**PORT WARATAH COAL SERVICES – TERMINAL 4 PROJECT (MP10_0215)
ADDITIONAL INFORMATION**

MITCHELL BENNETT
Head Regional Operations Unit – Hunter
Environment Protection Authority

**PORT WARATAH COAL SERVICES - TERMINAL 4 (MP10_0215)
GENERAL COMMENTS AND ADDITIONAL INFORMATION REQUIRED**

TITLE: **Proposed Development and Main Areas of Contamination**
Groundwater Assessment
Proposed Terminal 4 Project, Kooragang Island

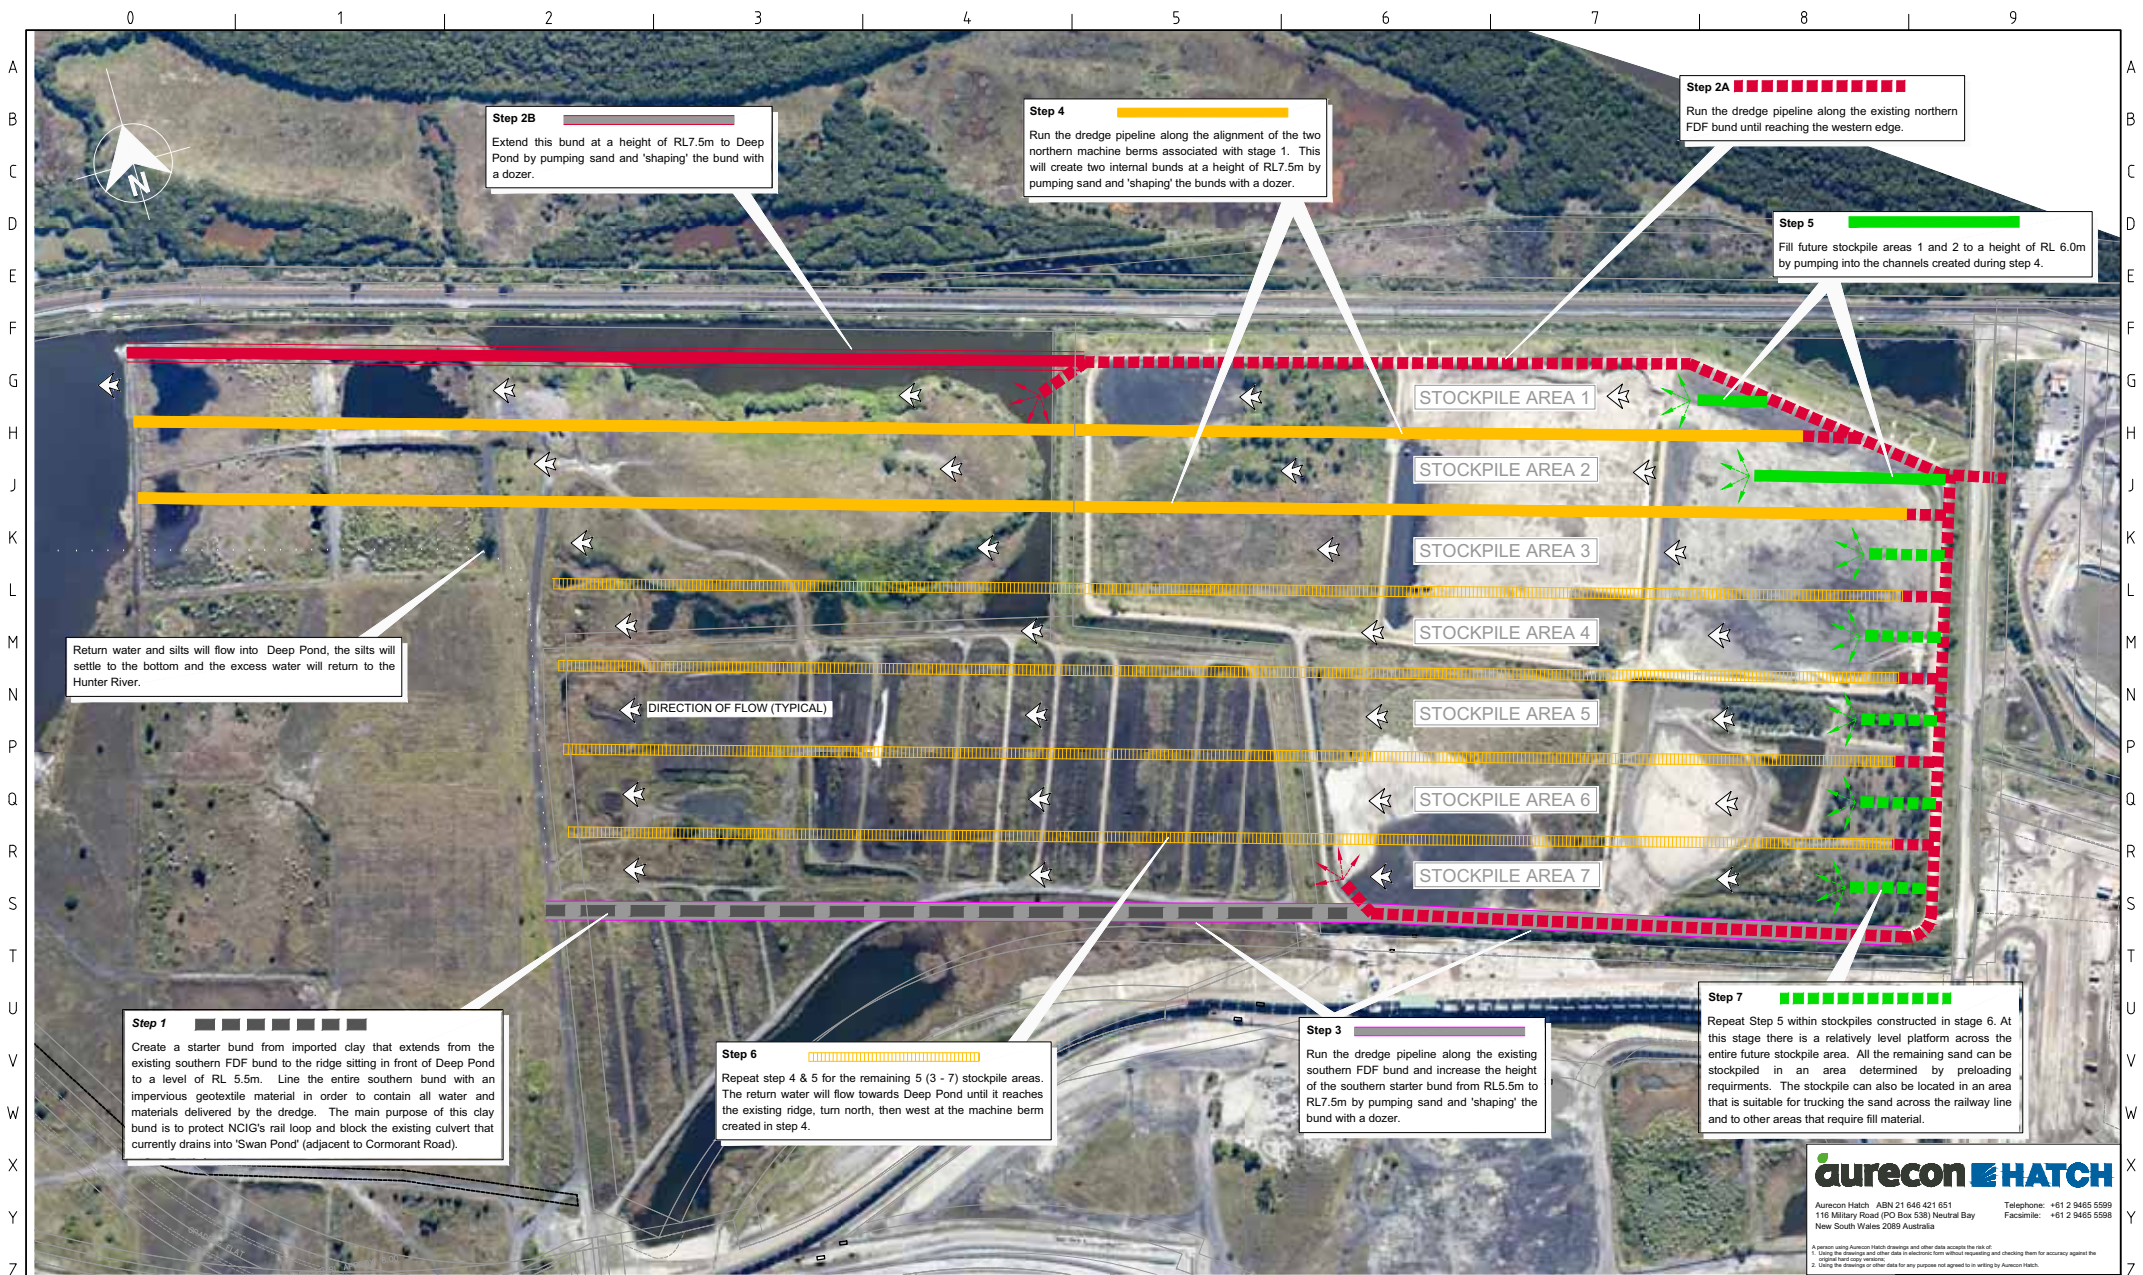
- **BHP Supply Area** (declaration 20122) - A proposed road extends through the BHP Supply area (refer area marked 'F' on Figure 7.3, Volume 1) which is declared as a remediation site and is regulated under the following Voluntary Management Proposals which have been agreed with the EPA and relevant landowners:

- # 26085 and #26059 require capping of PAH and manganese impacted soil to reduce groundwater infiltration;
 - # 26059 requires capping of TPH and PAH contaminated soil; and,

- # 20111712 requires the removal of free phase contaminants, construction of a barrier wall and capping of coal tar and PAH contaminated soil and groundwater (the capital works are due for completion by June 2013).
